## **OXFORDSHIRE COUNTY COUNCIL'S RESPONSE TO CONSULTATION ON THE FOLLOWING DEVELOPMENT PROPOSAL**

**Application no:** 23/02827/F

**Proposal:** Use of the eastern part of the southern taxiway and the adjacent Hush House building (Building 1368) for car processing operations plus associated works and portable buildings. Planning permission is sought for a 5 year period

## **Transport Schedule**

Figure 4.1 Proposed Vehicle Storage Areas

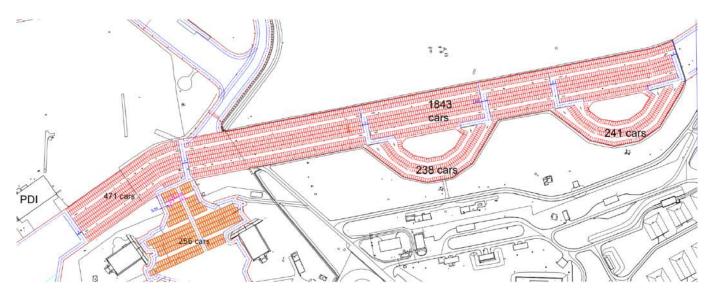
The most significant amendment to the TS is that the reference to “*approximately 3,800 vehicles are to be stored on site*” (TS version 2.3, sect 4.2.1) has been removed. The latest TS includes a plan of the temporary storage area (Fig. 4.1) with the most efficient use of space indicated for the vehicle parking. The total number of spaces is 3,049.

There has been a lack of clarity in the TS versions about the number of vehicles being stored (parked) and the number being processed. However, it is clear that the area of land covered by this application (for temporary permission) is the same as for previous applications, and so the scale of the operation is bound to be similar. In fact, the Area Plan submitted with 18/02169/F shows the area accommodating approximately 2,984 cars:

As the land area for storage remains unchanged, it follows that the potential number of car transporter movements will stay at roughly the same level as approved before.

The previous TS had stated that the storage would be approximately 3,800, so there would have been a significant intensification and, hence, the objection from OCC. As it is now more reasonably suggested that the storage will be about the same as before, it is considered that an objection cannot be maintained.
